Please ask for: Nicola Moore
Email: nicola.moore@arun.gov.uk
Telephone: Ext 37944
Our Ref: LU/276/20/HH
Your Ref:
Date: 2nd November 2020

Application for Planning Permission for Works or Extension to a Dwelling

Development: Side Extension and 2 storey rear extension (Resubmission of previously approved LU/334/19/HH).
Location: Parkfield Worthing Road Littlehampton BN17 6SH

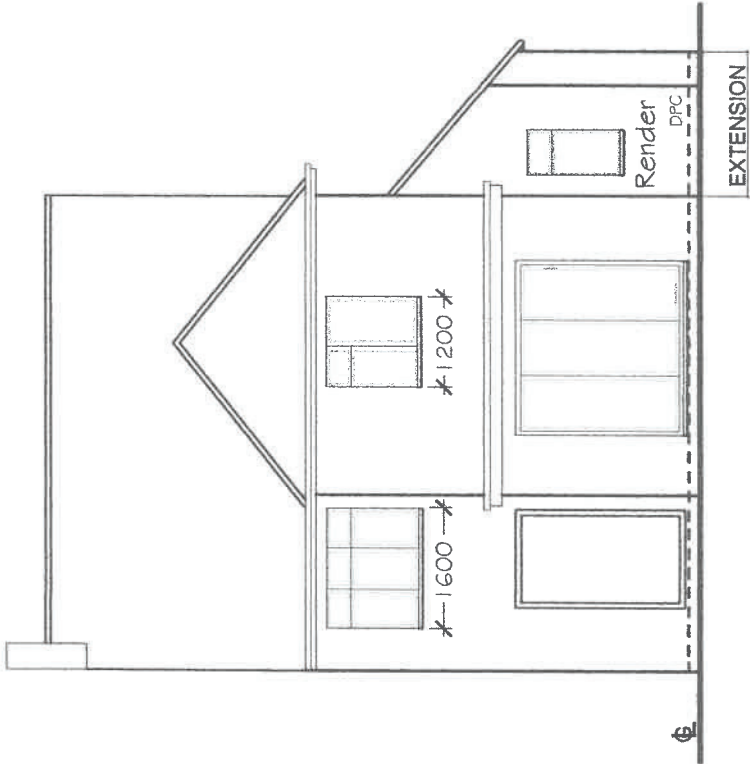
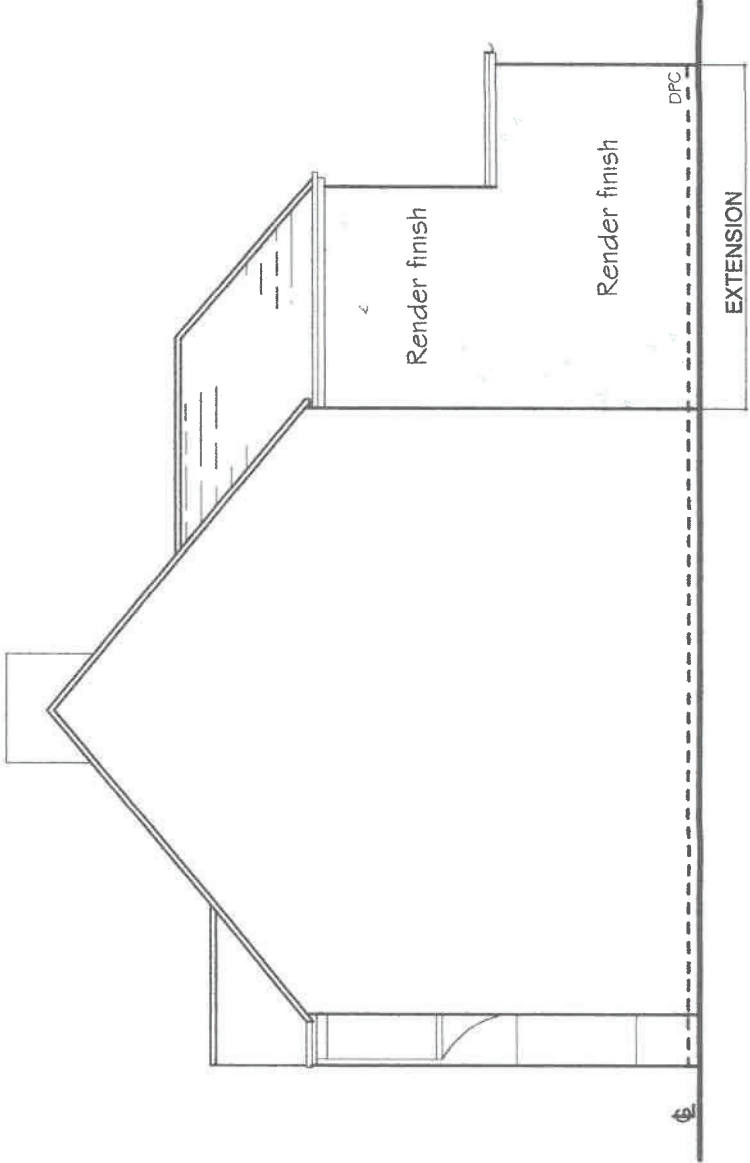
The first floor windows on the South Elevation measure 1.6m and 1.2m on drawing number 03 Proposed Elevations, and 1m and 1.2m on drawing number 04 Proposed Floor Plans. Please check the measurements, amend accordingly and resubmit.

As far as boundary measurements go you have 2 ordnance maps to scale, you have existing floor plans with boundary measurements on, I suggest you use them. If the window measurement varies put forward the 1.6 and stop being awkward

DRAWING
BLOCK PLAN

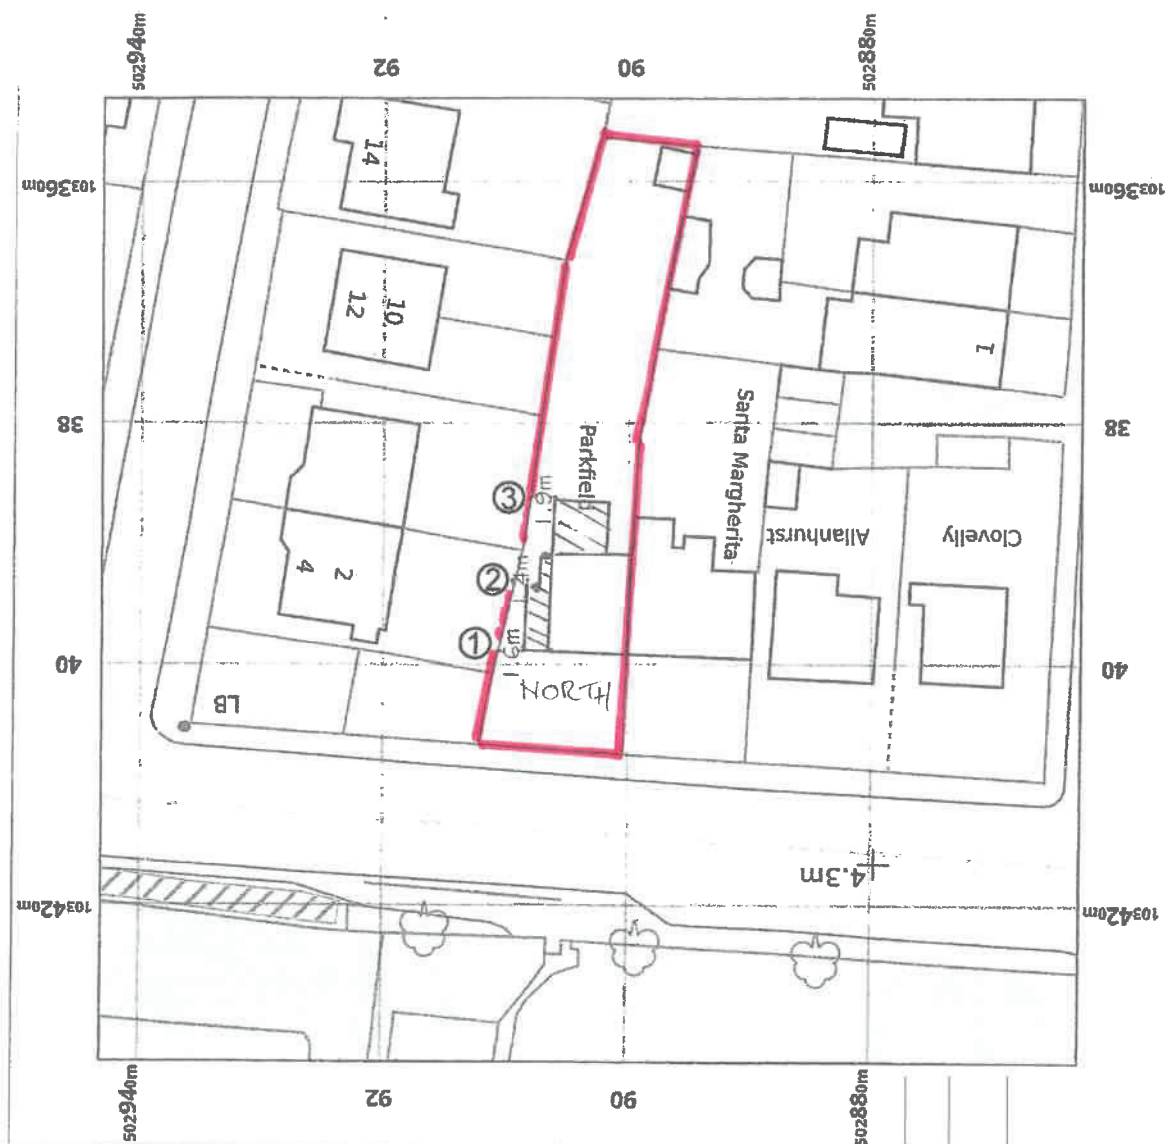
Block Plan

Please include written dimensions to boundaries and re submit.
CIL Additional Information Form
